**KIRKLEES METROPOLITAN COUNCIL
INVESTMENT & REGENERATION SERVICE**

DELEGATED DECISION TO DETERMINE PLANNING APPLICATIONS

Reference No: 2017/62/92986/W

Description: Erection of agricultural worker's dwelling

J M & V J Howard
Proposed Agricultural Worker's Dwelling at Deer Hill End Farm, Meltham
Block Plan 1:500 @ A4 July 2017

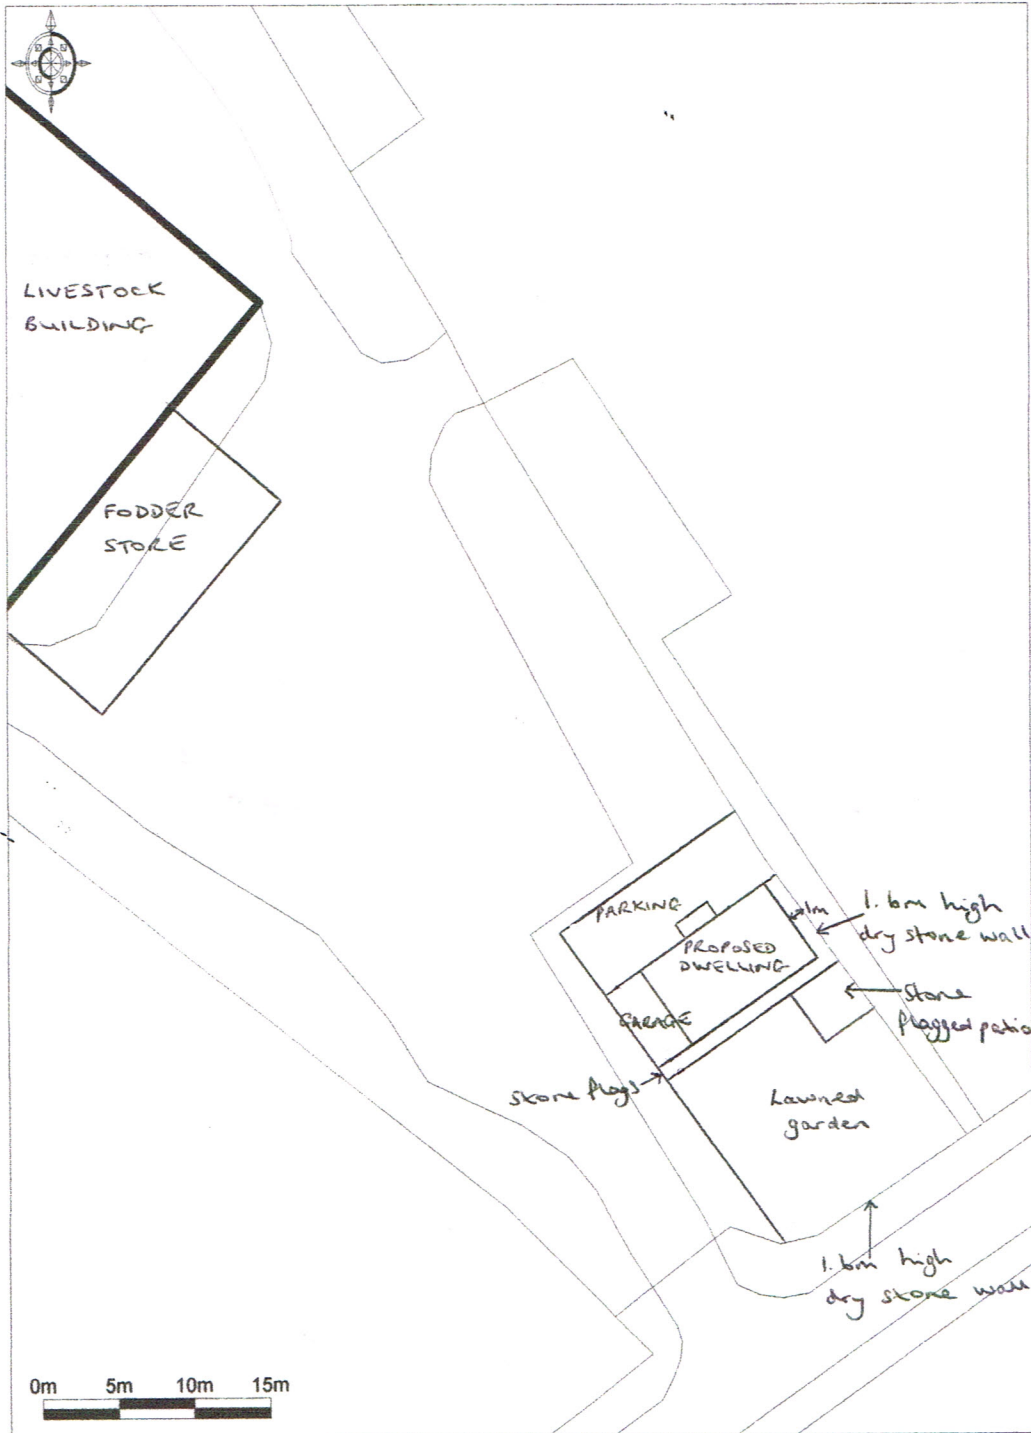
The dwelling is shown to be set back into the site 15m from the edge of the access road (Deer Hill End Road). The front of the dwelling would be facing the yard and existing agricultural building to the north, with the rear facing towards the access road and bridleway towards the south. The main entrance would be served by a small porch with a parking area beyond.

Due to the surrounding land levels, given the open rural setting of this site the proposed two storey in the siting proposed, adjacent to the road and bridleway would be fairly prominent. The scale and prominence of it within the surrounding landscape would be mitigated somewhat by the existing large agricultural buildings to the north and consequently the impact on the Green Belt can be argued to be reduced. However, to maintain an open character, it is considered necessary to withdraw permitted development rights for any additional buildings or extensions within the red line boundary which defines the residential curtilage for the proposed dwelling, so as to avoid undesirable new structures prejudicing the openness of the Green Belt. A dry stone wall exists along the southern and eastern boundaries to be retained. A condition, restricting the residential area within the application red line and retention of the existing boundary treatment is considered necessary to preserve the openness of the green belt and to avoid further encroachment into the green belt. This would also safeguard the bridleway and convenience of those using it. Subject to the above details of materials (stone) to be approved the proposed agricultural workers dwelling is considered acceptable in the siting shown from a visual amenity perspective and would accord with aims of policies BE1, BE2 and BE11 of the UDP the aims chapters 7 and 9 of the NPPF and Policy PLP 58 of the PDLP.

The development would be accessed via the existing access lane from Deer Hill End Road. With regards to parking provision for domestic vehicles these would be accommodated in the attached garage and proposed parking area between the proposed dwelling and existing agricultural building. Since the dwelling would be associated with the existing farming enterprise, it is not anticipated that there would be any significant intensification of use of this existing access road. On the basis of the above, the proposals are not considered to materially add to any highway safety implications and would accord with the aims of Policy T10 of the Unitary Development Plan and PLP 21 of the PDLP.

4. Notwithstanding the submitted plans the existing dry stone walls along the application east and southern boundaries shall be retained at all times. The domestic curtilage for the dwelling house hereby approved, shall be limited to the area outlined in red on the location and the approved site block plan, excluding the access along Deer Hill End Road.
